2/13/2025

SUBJECT: **SFD2404-0104**
SINGLE FAMILY DWELLING

Here are the results of all Inspections located at **3492 OLIVIA RD:**

**PLACEMENT PLAN**

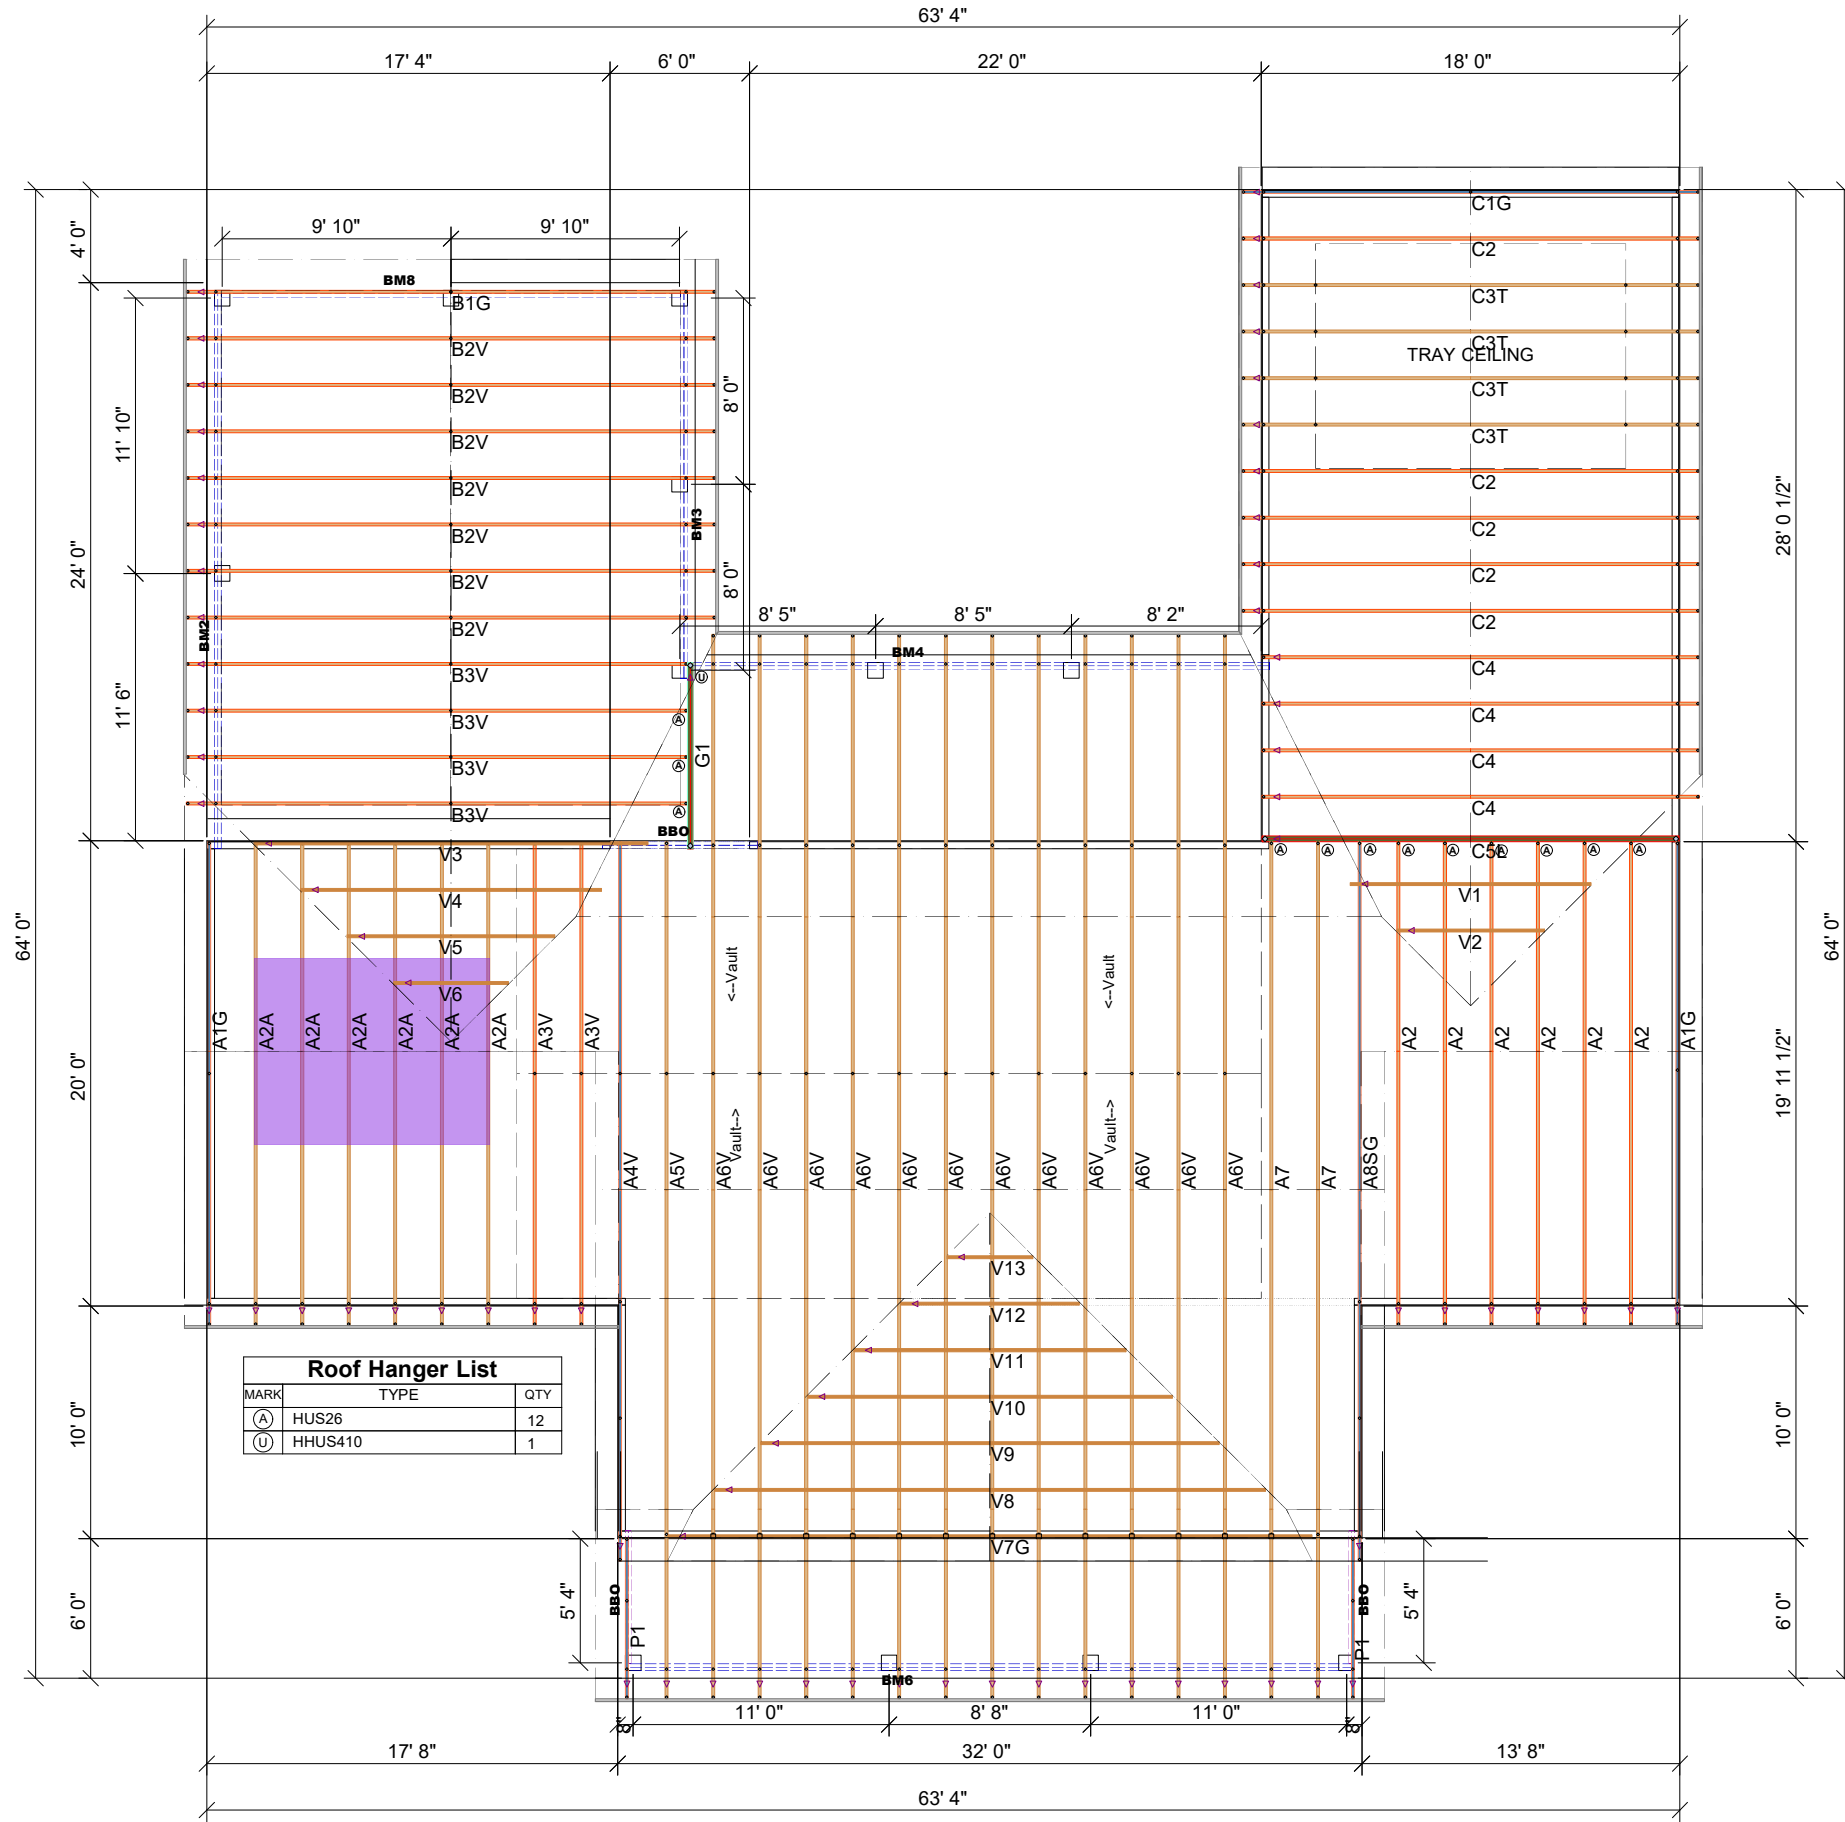
1. 6ft window in kitchen needs 2 kings studs each side also window not installed at time of inspection but was covered 2. Missing a piece on the top plate under a truss at back door in kitchen area 3. Need to strap top plate where it's notched out for the porch beam 4. Seal top of chase between master bathroom and other bathroom 5. Missing nails in hangers above master bathroom 6. Fire stop penetration for thermostat 7. Need 24" straps on each side of the front door header for the broken top plates 8. Dryer vent not completed 9. Missing nails in hangers on the back porch 10. Electrical wires come out of the house below the ceiling line on the back porch 11. The hangers on c5l are not the correct hangers truss docs call for 26 hangers and they need to have 16d nails 12. Girder truss needs to be nailed together per truss sheet 13. Double 2x10 on each end of the front porch have no support under them at lvl 14. Missing nails in the hurricane clips on rear wall 15. Missing hurricane clips on the front and back porch 16. Anchor bolts need to be in the center 1/3 to the right of the front door 17. Need 2 anchor bolts per member in the bathroom by laundry

Inspection Type: ROUGH IN REINSPECT
Scheduled Date/Time: 1/21/2025
Completed Date/Time: 1/21/2025
Inspector: John B Kokoszka
Result: DISAPPROVED
Remarks:
Notes: Items 2 need to be strapped 3,5, 12,14,16 Missing baffles

Missing window. Missing blow in depth gauges. How will attic insulation be blown in on master side of the house with no access framed out? Cannot access other side of house from mechanical platform. Note: Both windows on each side of back door will have to be tempered.
